Consultation Response from KC, Trees
2024/92236 Wood Street Mills, Wakefield Road, Scissett, Huddersfield, HD8 9JS
Demolition of existing industrial building and erection of storage and distribution building with car park and associated engineering works
Date Responded: 26/09/2024 Responding Officer: JD Responding Ref:

Appendix 2 Tree Protection Plan

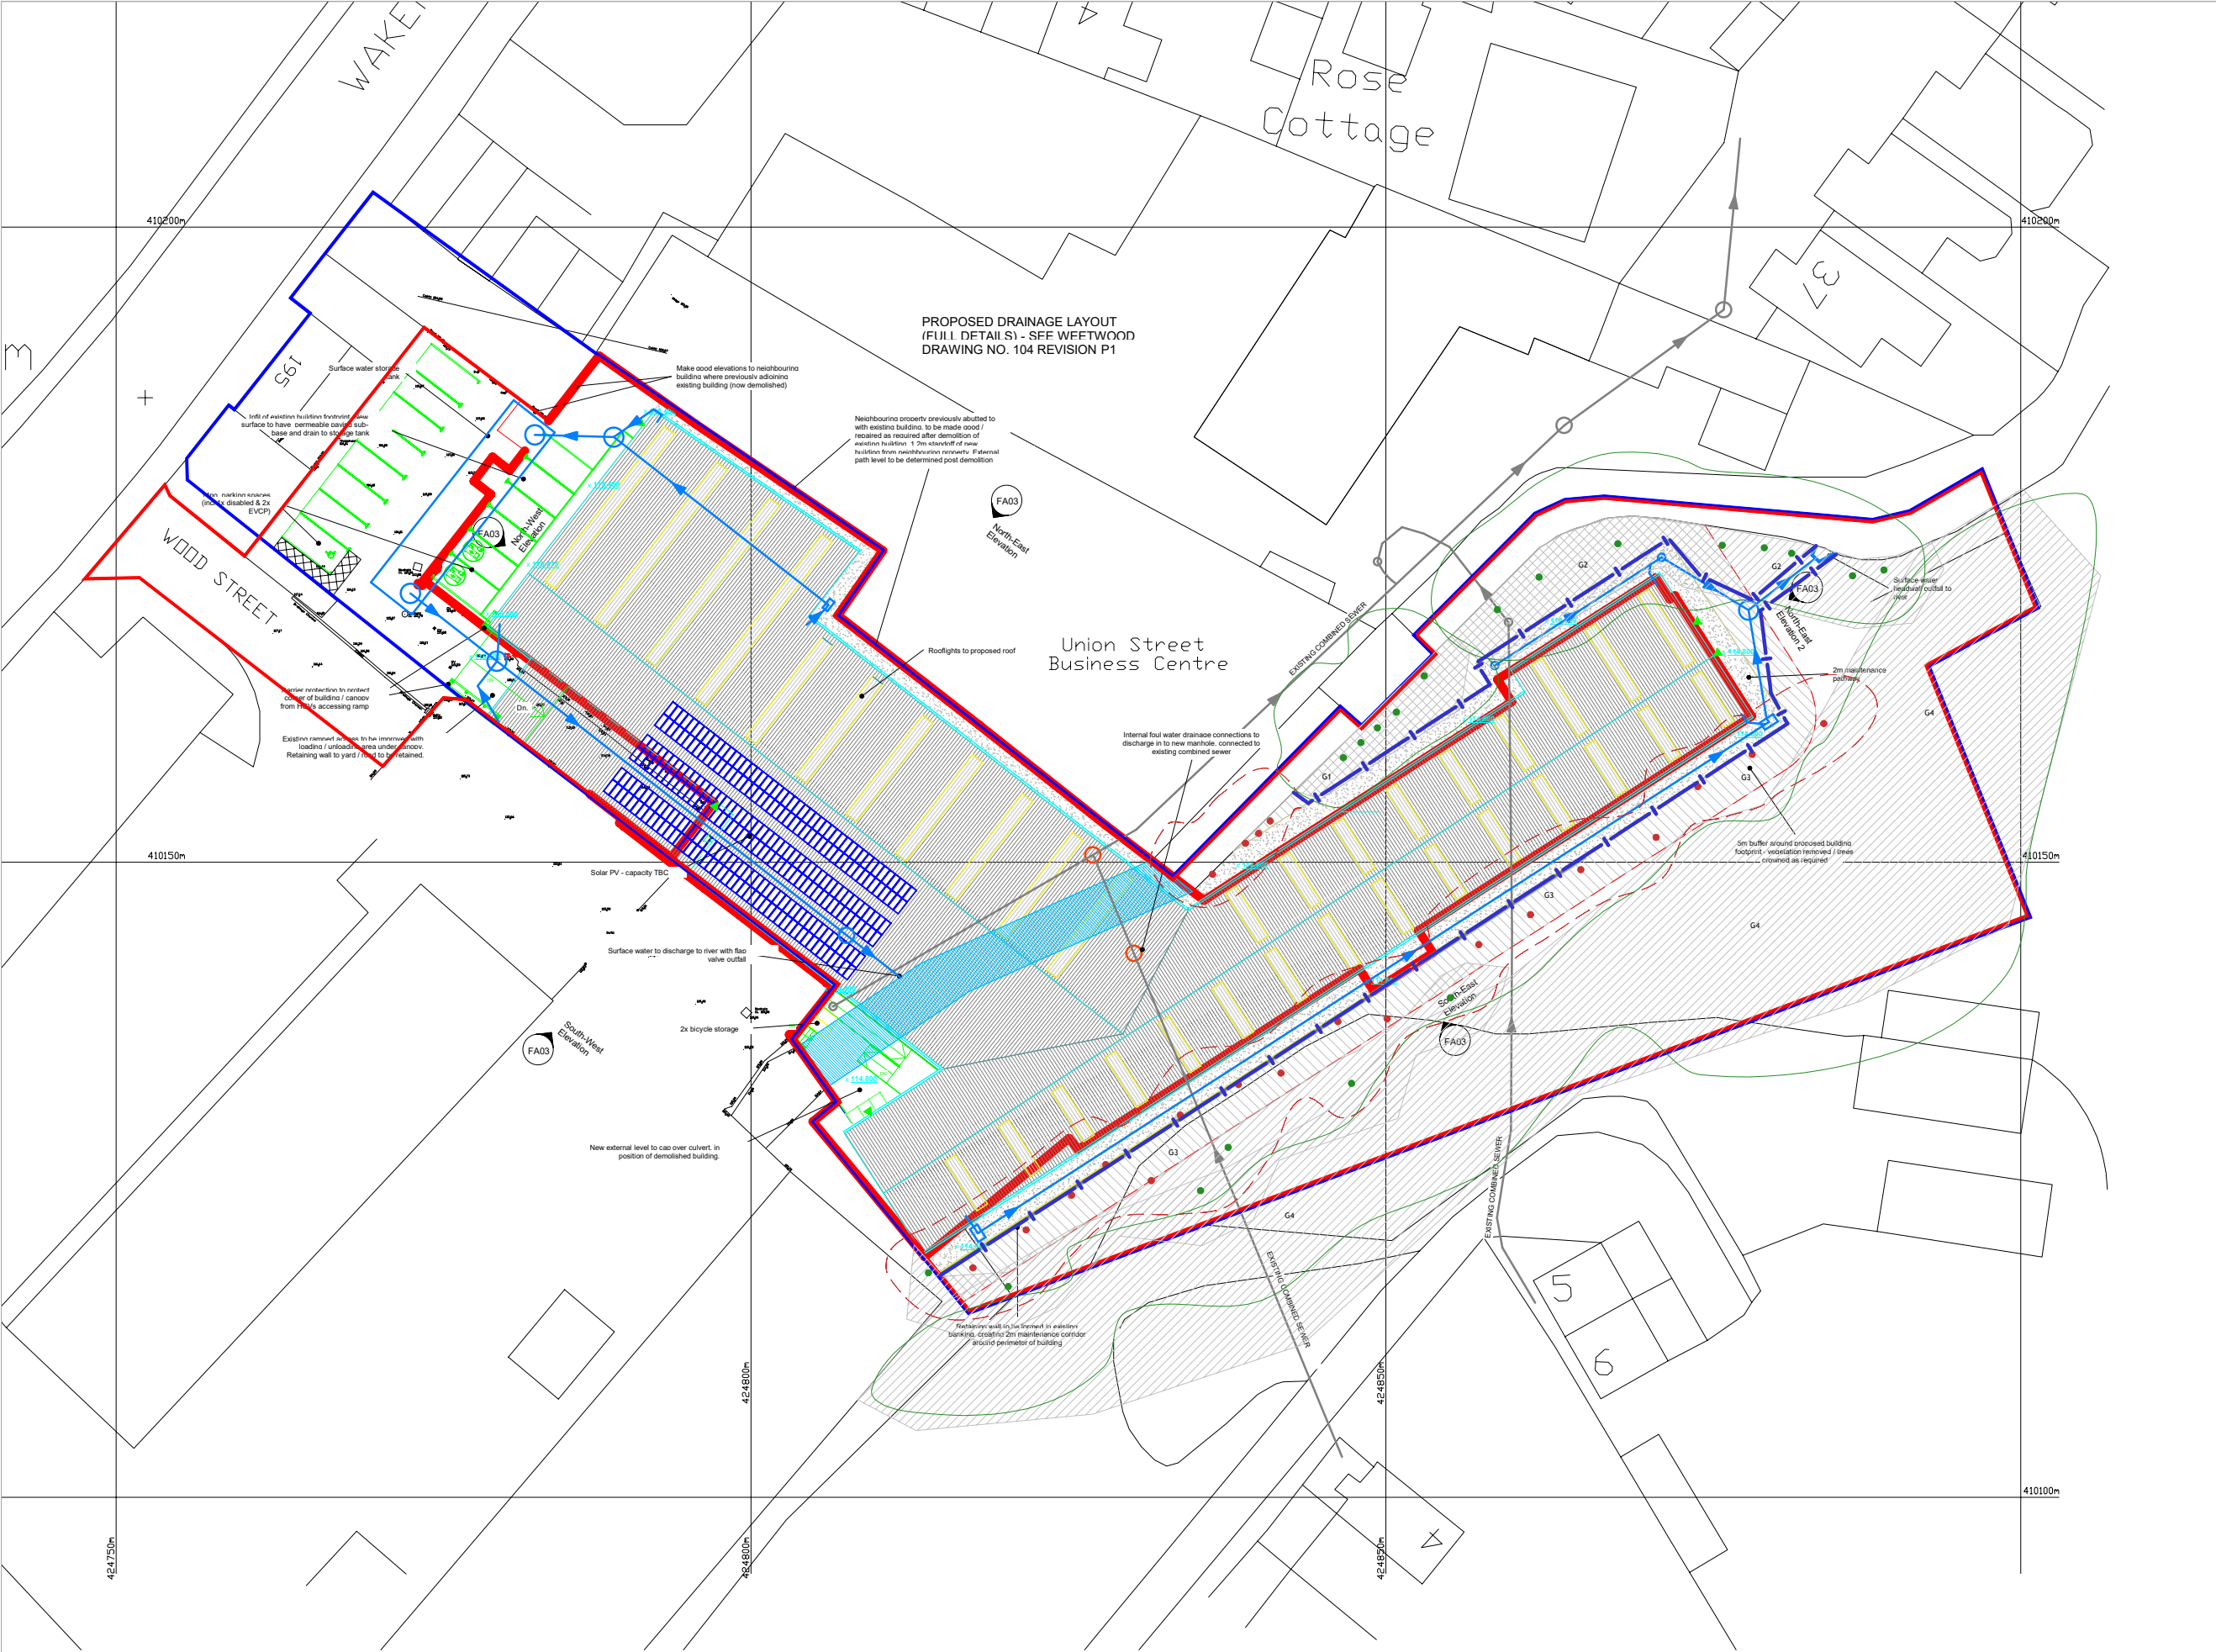
After reviewing the new Arboricultural Impact assessment it is clear that there is a thin layer of trees that are situated directly adjacent to the existing building (Part of G1 and G3) to be removed. They are category C trees which are mostly hidden from view to the wider area and therefore hold very little amenity value. The tree loss proposed is tolerable and shouldn't poses any difference on the wider landscape.

The tree protection plan also sufficiently details the steps that will be taken to ensure the retained trees are protected during construction.
